STERLING RANCH EAST FILING 5 PRELIMINARY PLAN

LETTER OF INTENT

AUGUST 2023

Please see comments provided by engineering on the Letter of Intent for Sterling Ranch East Filing 5, P237, and update accordingly.

Include hatching in legend

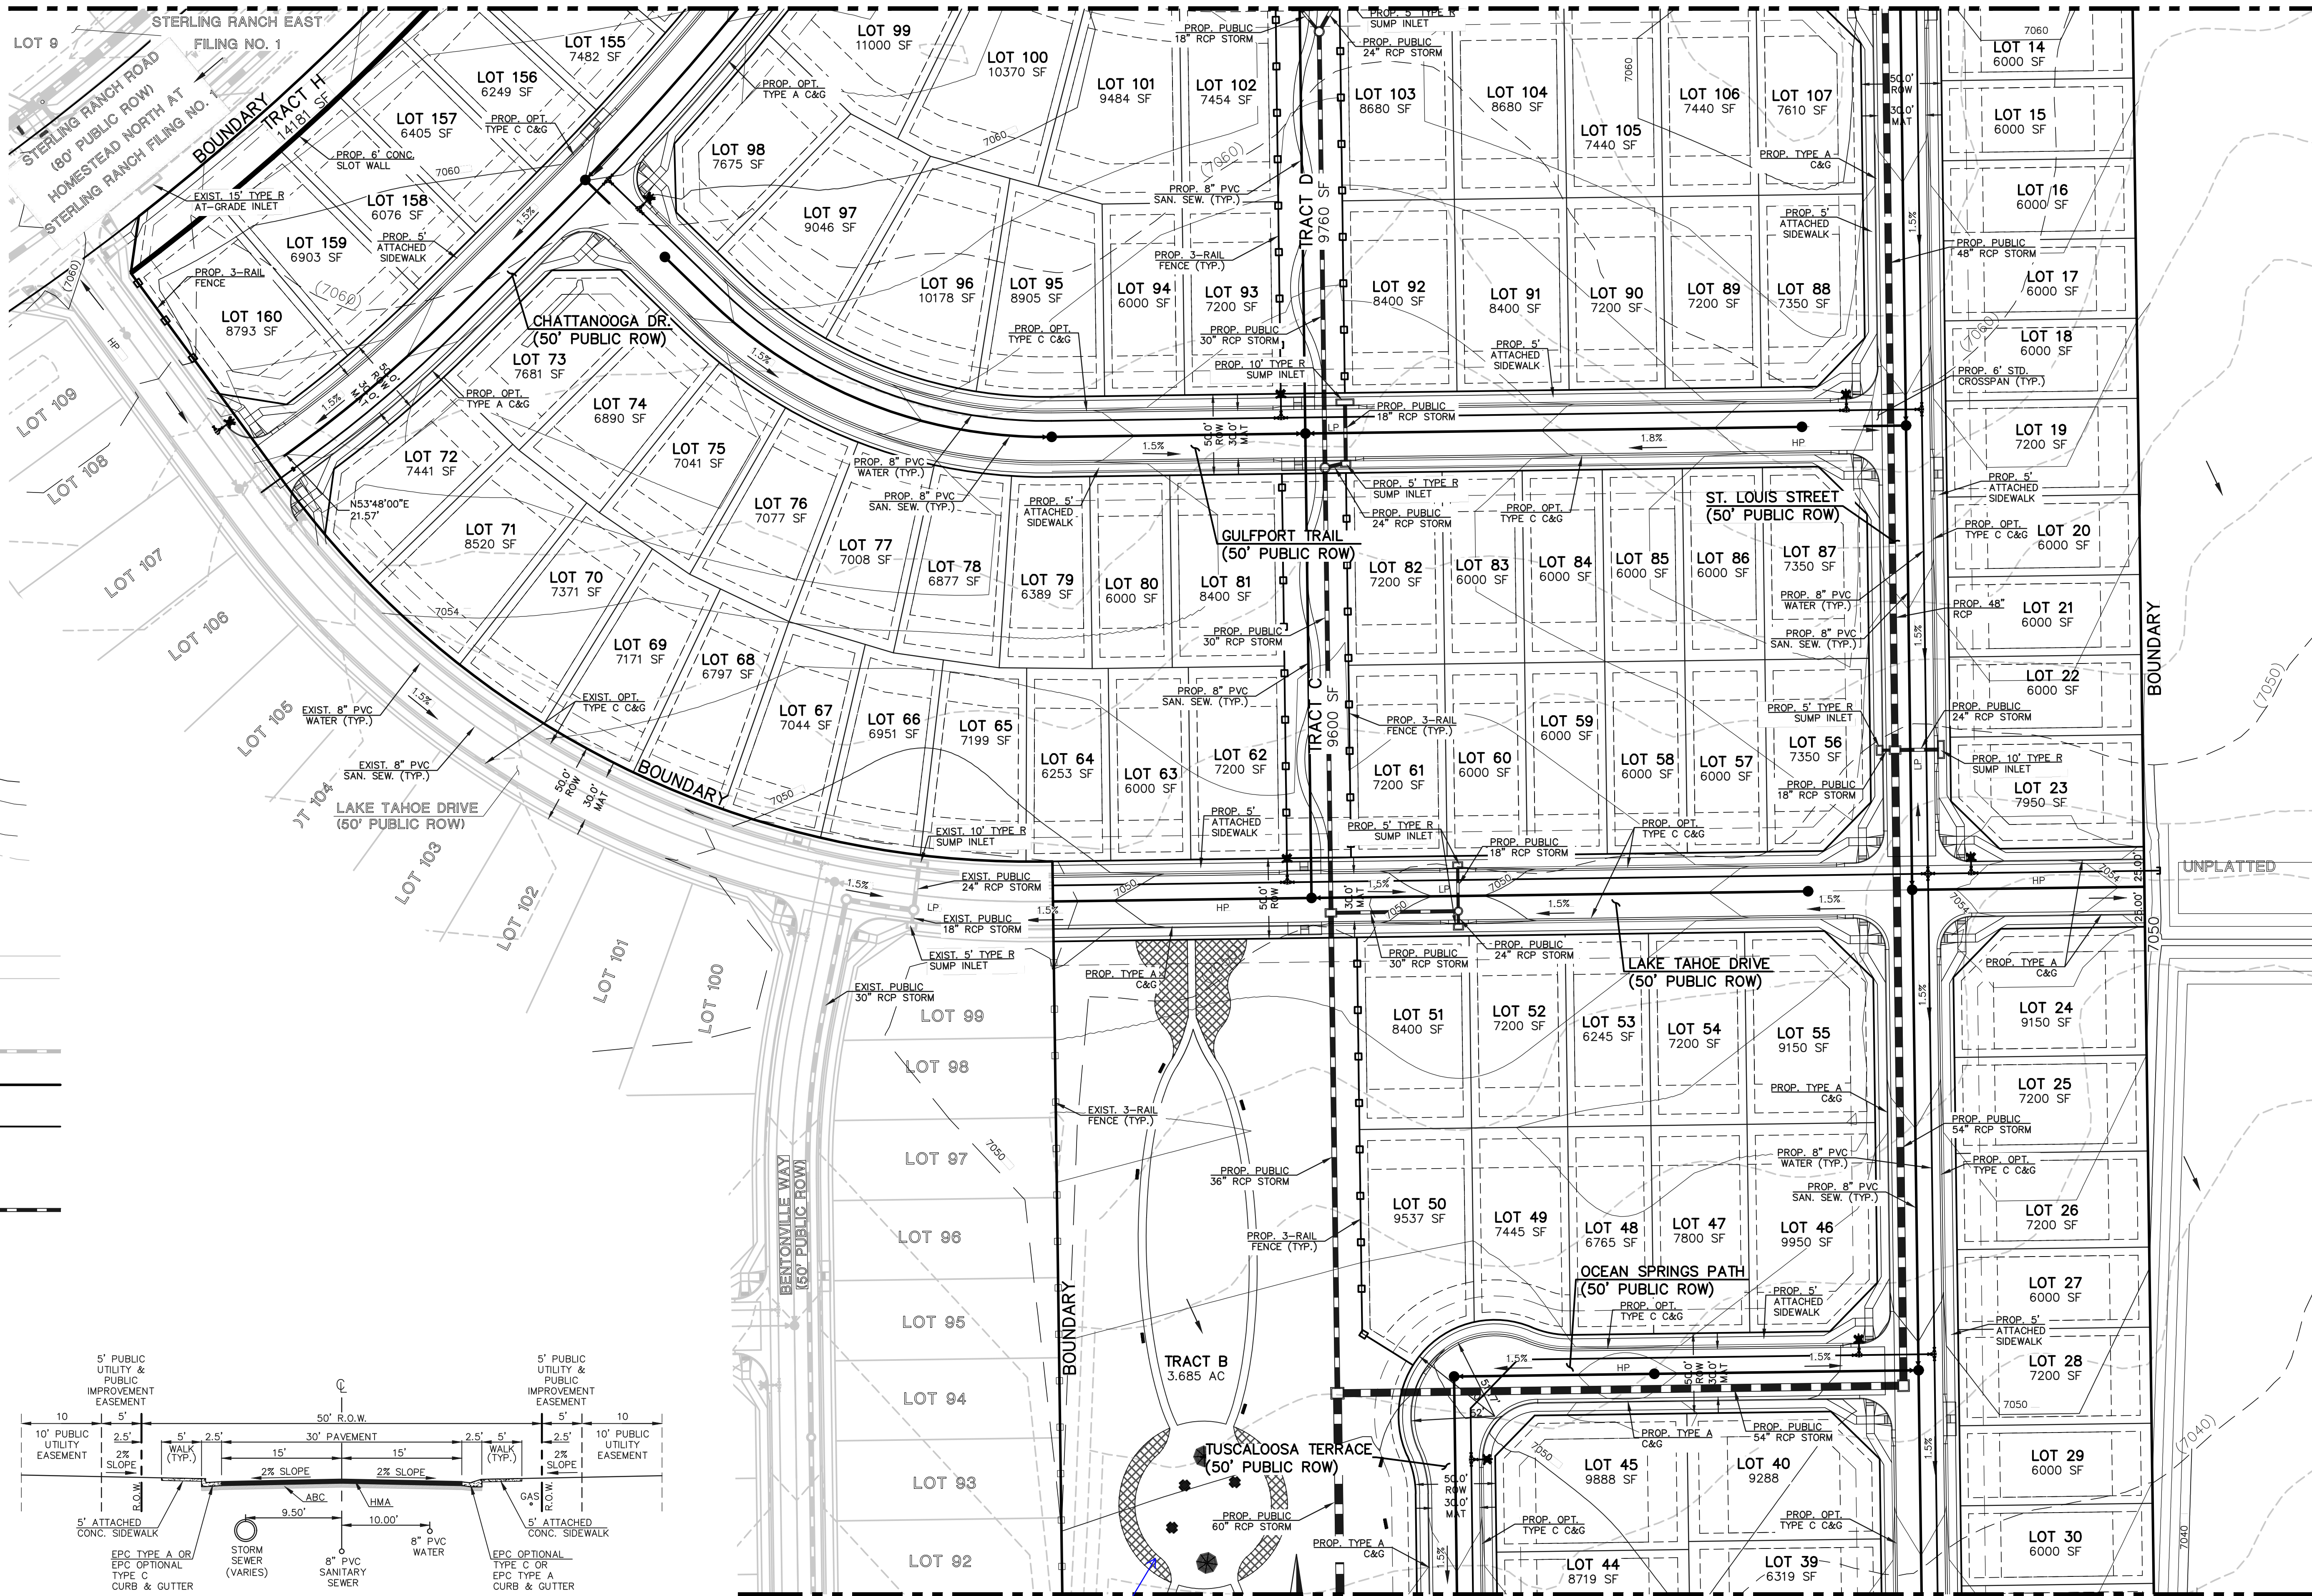
Sterling Ranch Road does not require noise mitigation as it is classified as a collector, but the 6' concrete panel noise wall is continued along Sterling Ranch Road screening for privacy and to provide a consistent development identify. A detail of the 6' concrete panel wall is provided in the preliminary plan set (sheet 18).
